23 October 2014

RE: WEST CULBURRA – WATER CYCLE MANAGEMENT REPORT - PEER REVIEW

Further to previous reviews, I have conducted further analysis on the Martens Water Cycle Management Report P1203365JR01V05 dated August 2014. Generally, the report complies with my previous recommendations.

Figure 11

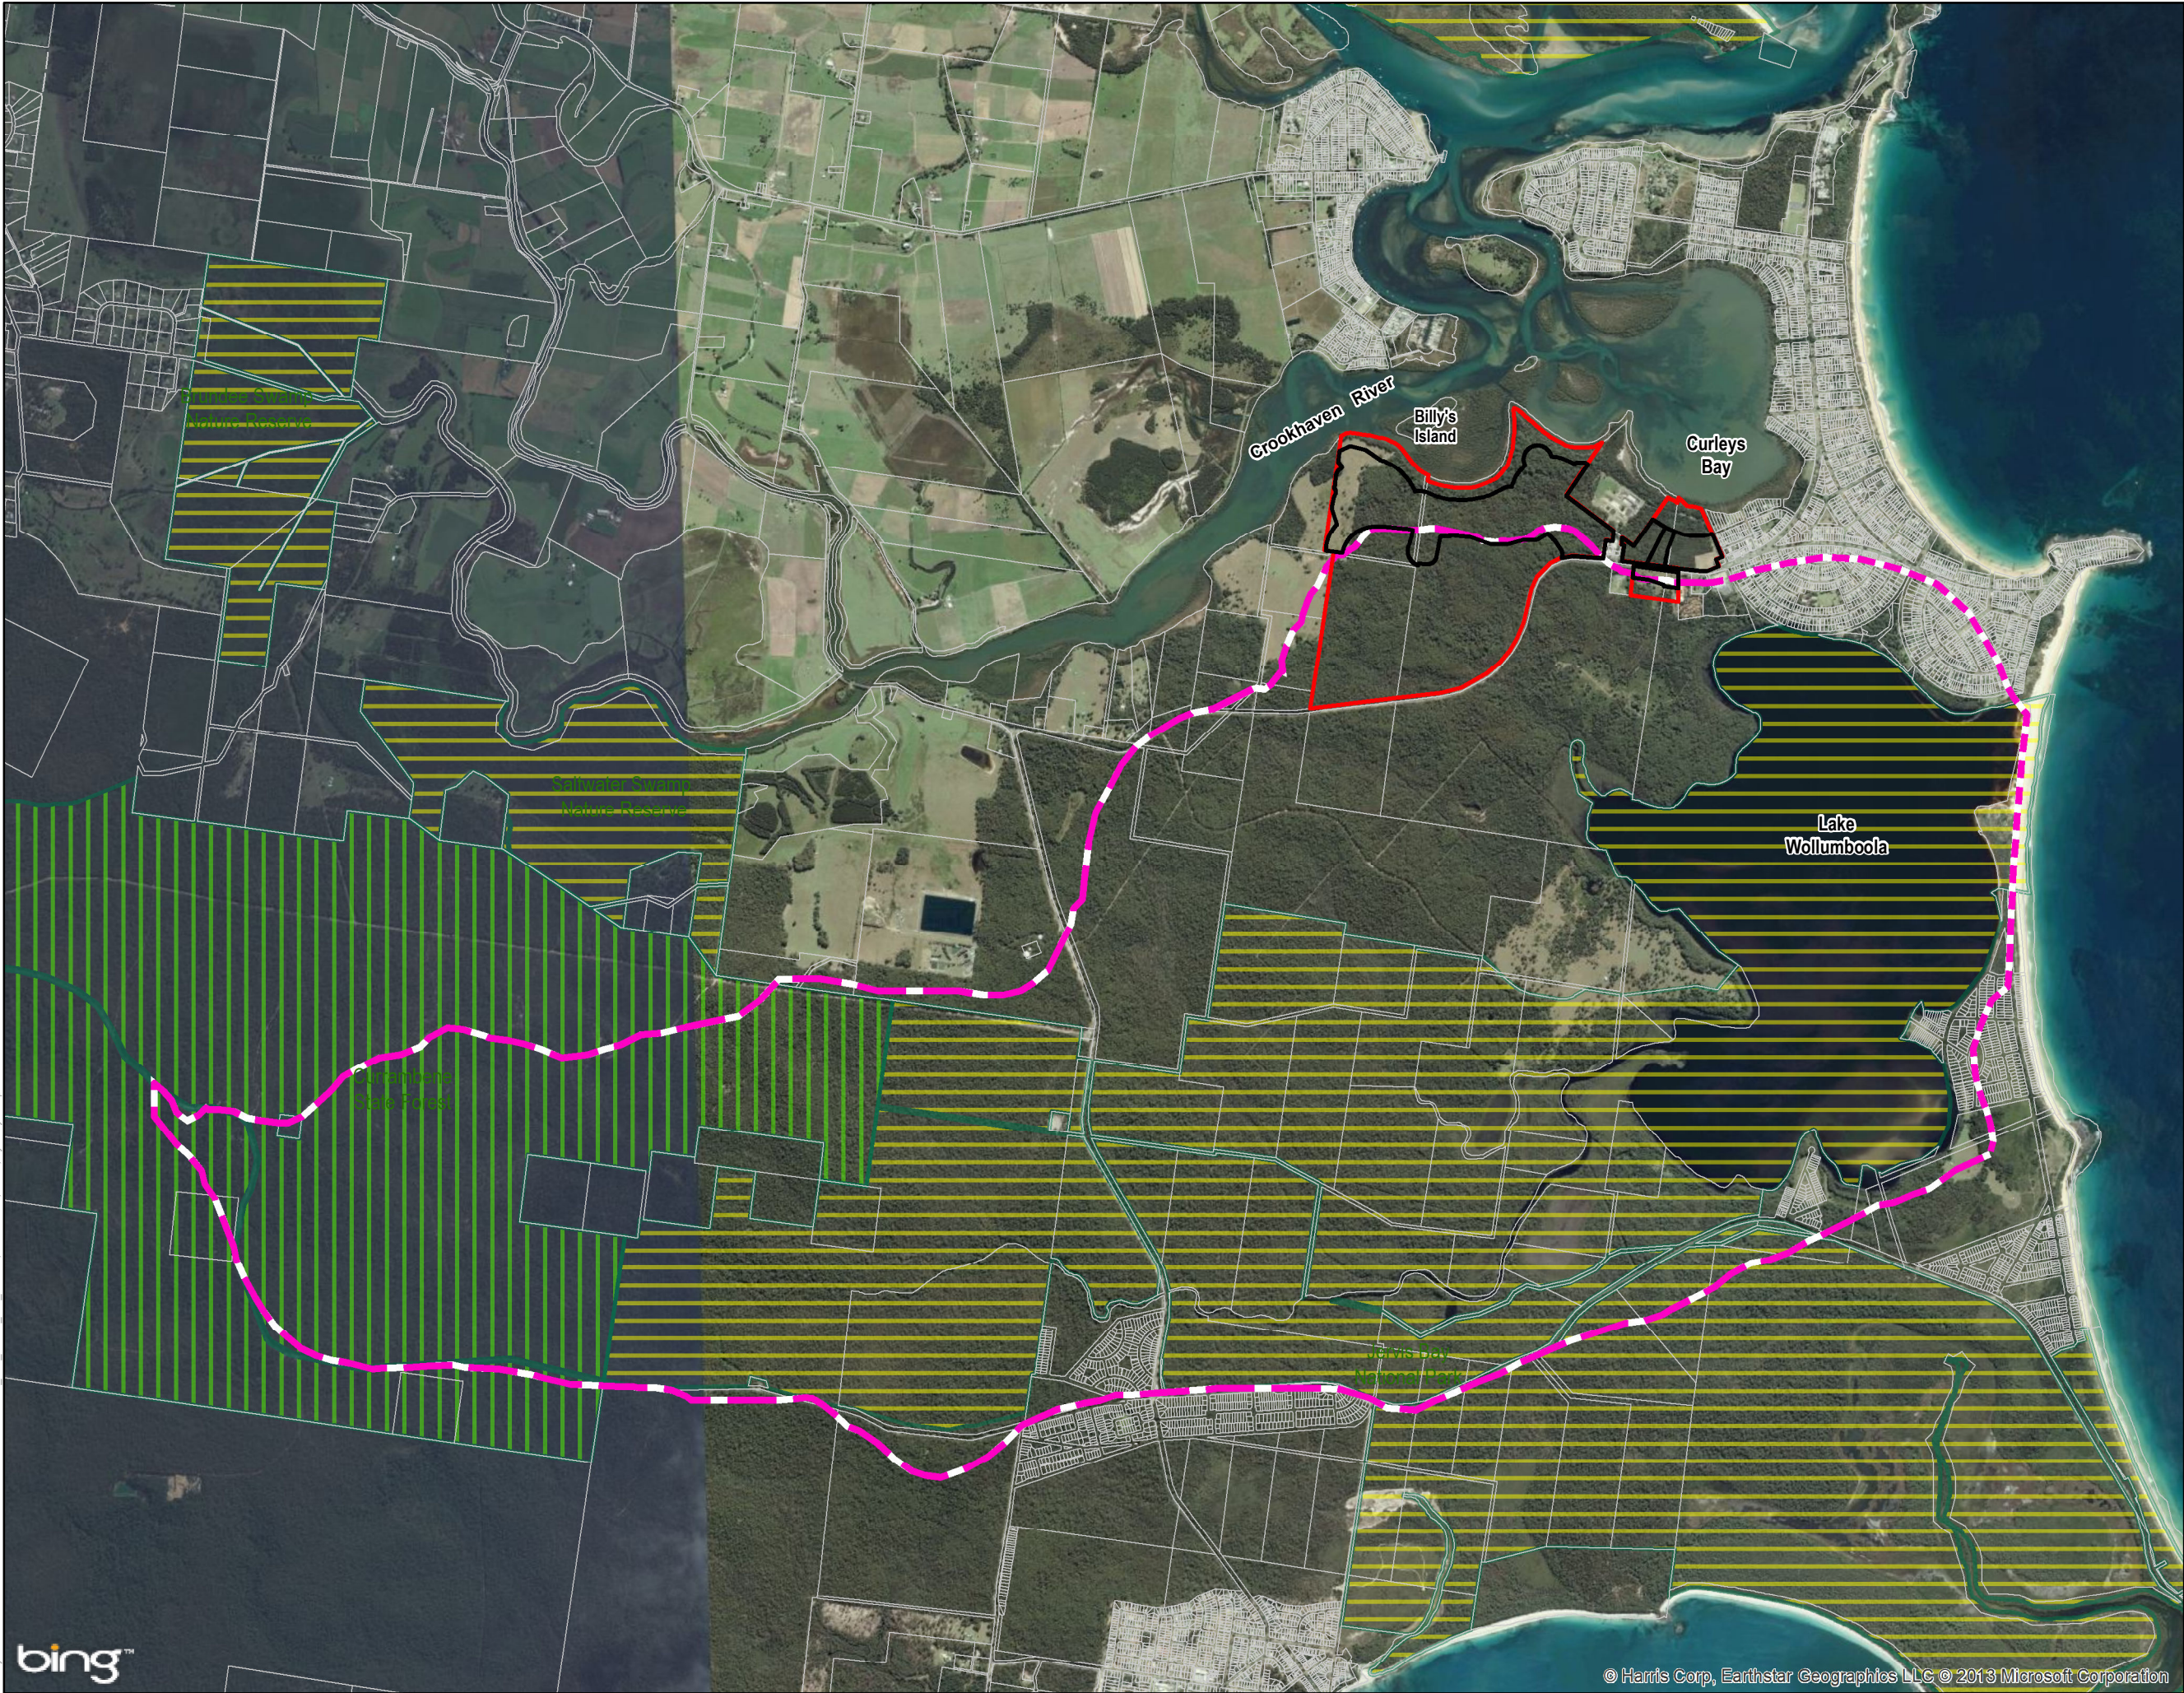
3. I note that the proposal still contains development which will drain to Lake Wollumboola. It was my understanding that this was not allowable given the sensitivity of the Lake to any increases in pollutant loads.
